# Charlotte Department of Transportation

## Memorandum

**Date:** March 6, 2008

**Subject:** Rezoning Petition 08-059: Located on the east side of the I-85 and City Boulevard Interchange

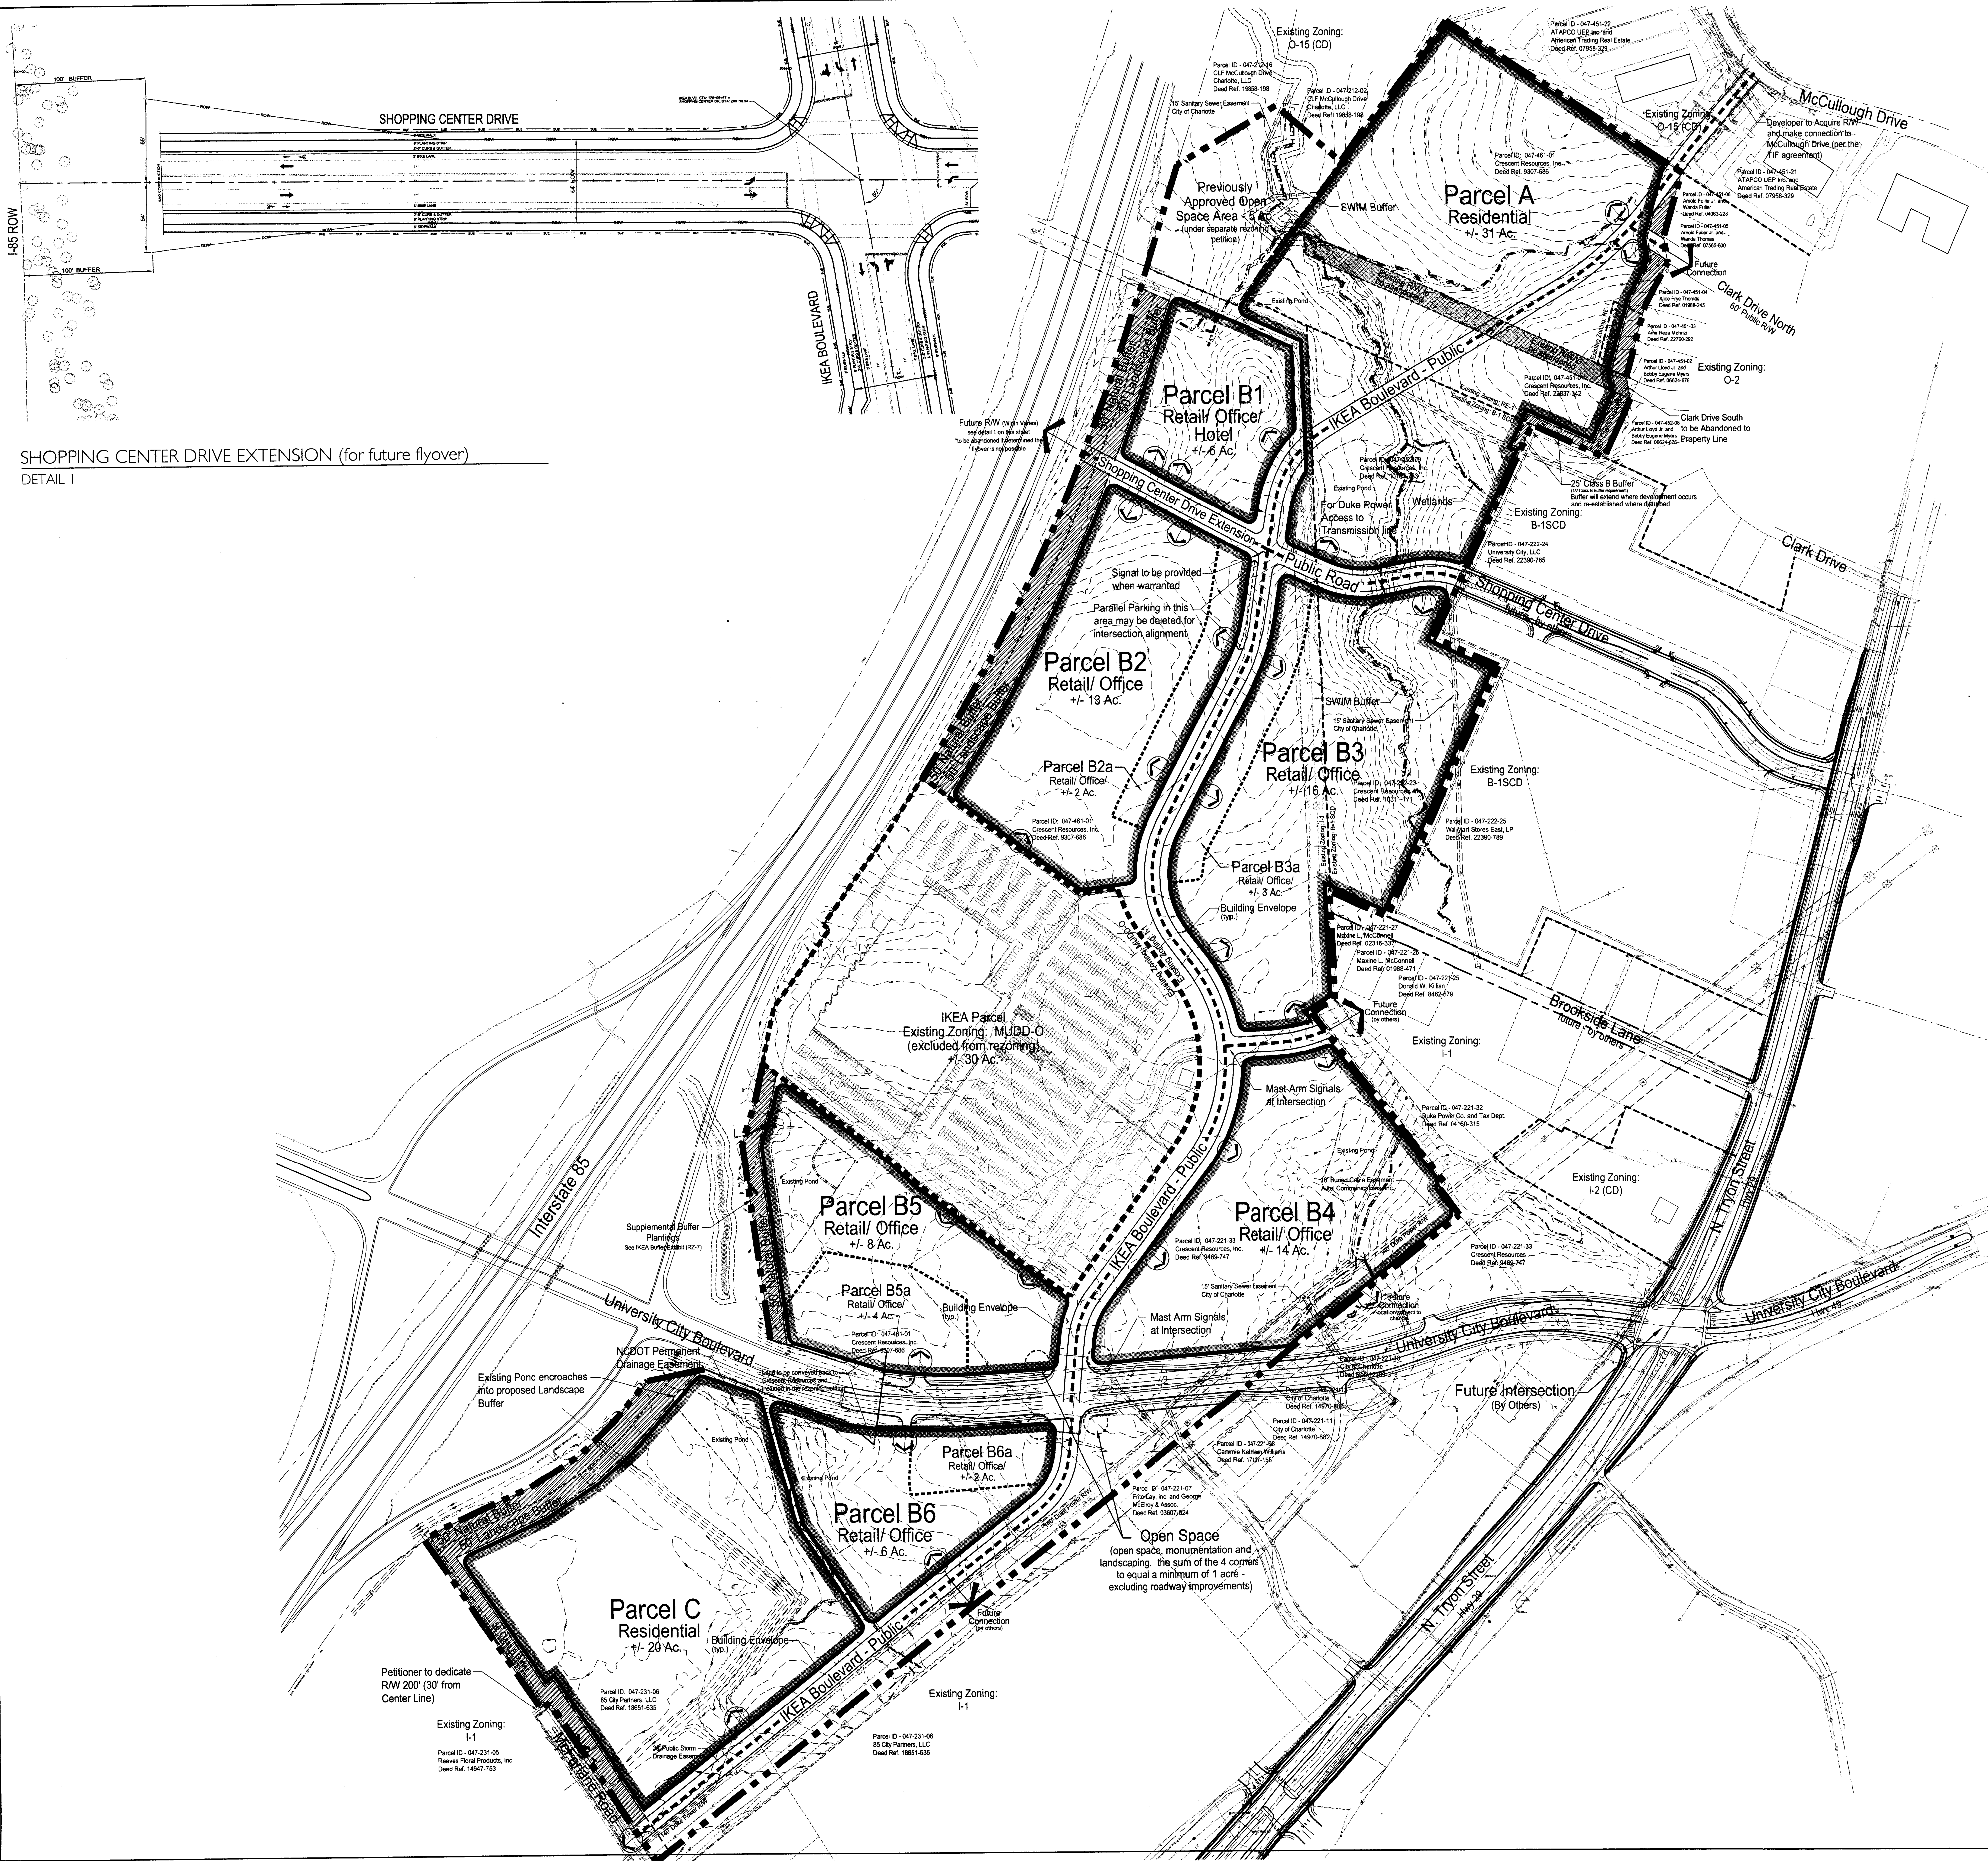
4. The right-of-way (62 feet) shown on the site plan for the extension of Shopping Center Drive across I-85 is insufficient. It is anticipated that at least 90 feet of right-of-way will be necessary to accommodate the required cross-section and that additional right-of-way will be necessary for slopes near the future bridge over I-85.

5. The alignment for the extension of Shopping Center Drive shown on the site plan has not been determined at this time. What is shown on this site plan is likely to change. CDOT has retained a consultant to study the best alignment and necessary right-of-way. In the event that the final alignment is not determined by the City prior to the Council's decision on this rezoning request, a note needs to be added to the site plan that indicates the petitioner/developer will make any necessary adjustments to the development plan, dedicate appropriate right-of-way/easements, and agree to incorporate the final alignment in the first subdivision plan submittal for this portion of IKEA Boulevard.

6. The proposed roundabout at the IKEA Boulevard/Shopping Center Drive intersection needs to be designed with a maximum outside diameter of 130 feet, corresponding to an "urban single-lane" roundabout as defined by the Federal Highway Administration.

7. The middle portion of IKEA Boulevard (from IKEA to Shopping Center Drive) is classified as an Avenue (Urban Street Design Guidelines, USDG). Cross-sections C-C and D-D need to reflect this. Due to the intensity of proposed development and the mix of land uses, 8-foot sidewalks need to be provided along IKEA Boulevard. All other local streets/cross sections will need to conform to the appropriate USDG street type.

10. All street dimensions, such as lane widths or parking bay widths, on sections A-A, B-B, C-C, and D-D need to be referenced to the face of curb instead of the back of curb.
